Re: Request for further information Y/26/26/HH

Proposed - First Floor Plan
scale 1.100 @ A3

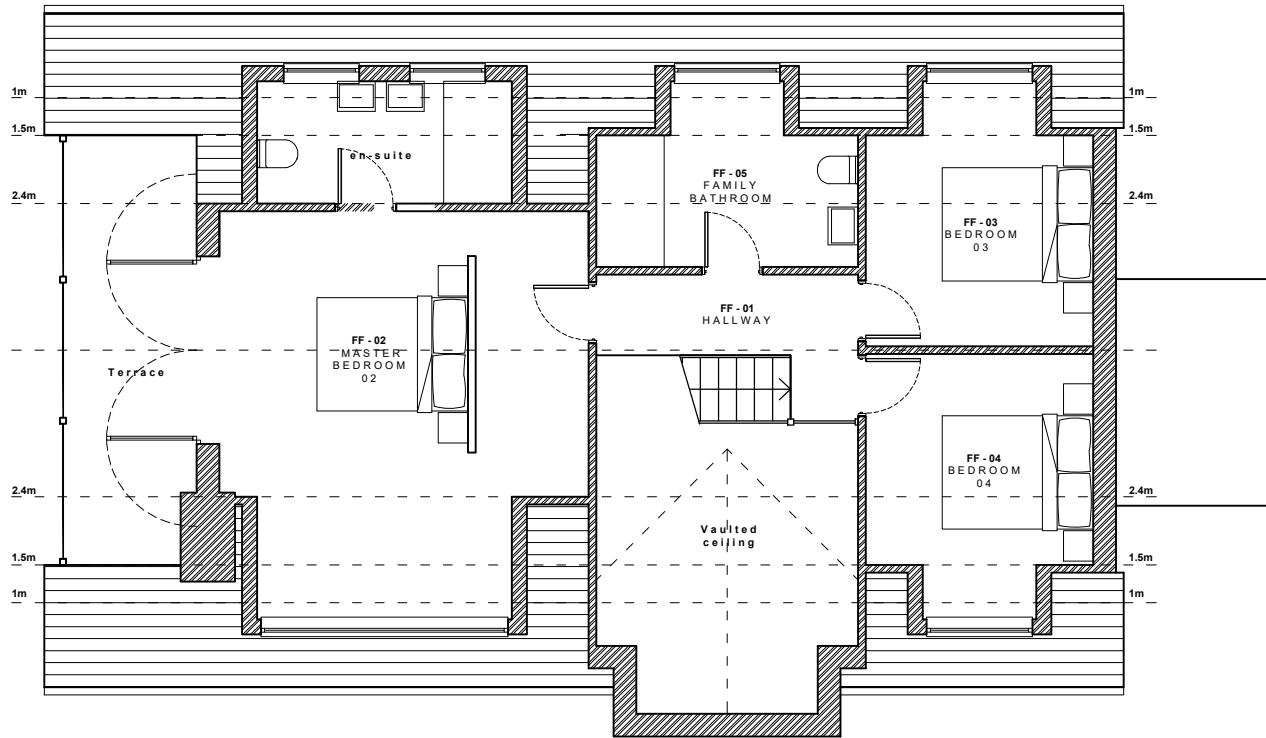
- Proposed ground floor plans do not show supporting columns of balcony area
- Proposed first floor plans: the windows of the ensuite do not align with the NW elevation.
- The roof plan and first floor plan area labelled 'vaulted ceiling' do not align with the height of the porch shown on the SE elevation
- NE elevation does not show the smaller dormer windows.
- The site plan measurements do not scale as labelled. There should not be discrepancies between measurements of 50-100cm or more.

I have crossed referenced all openings and edges and insure they all align.
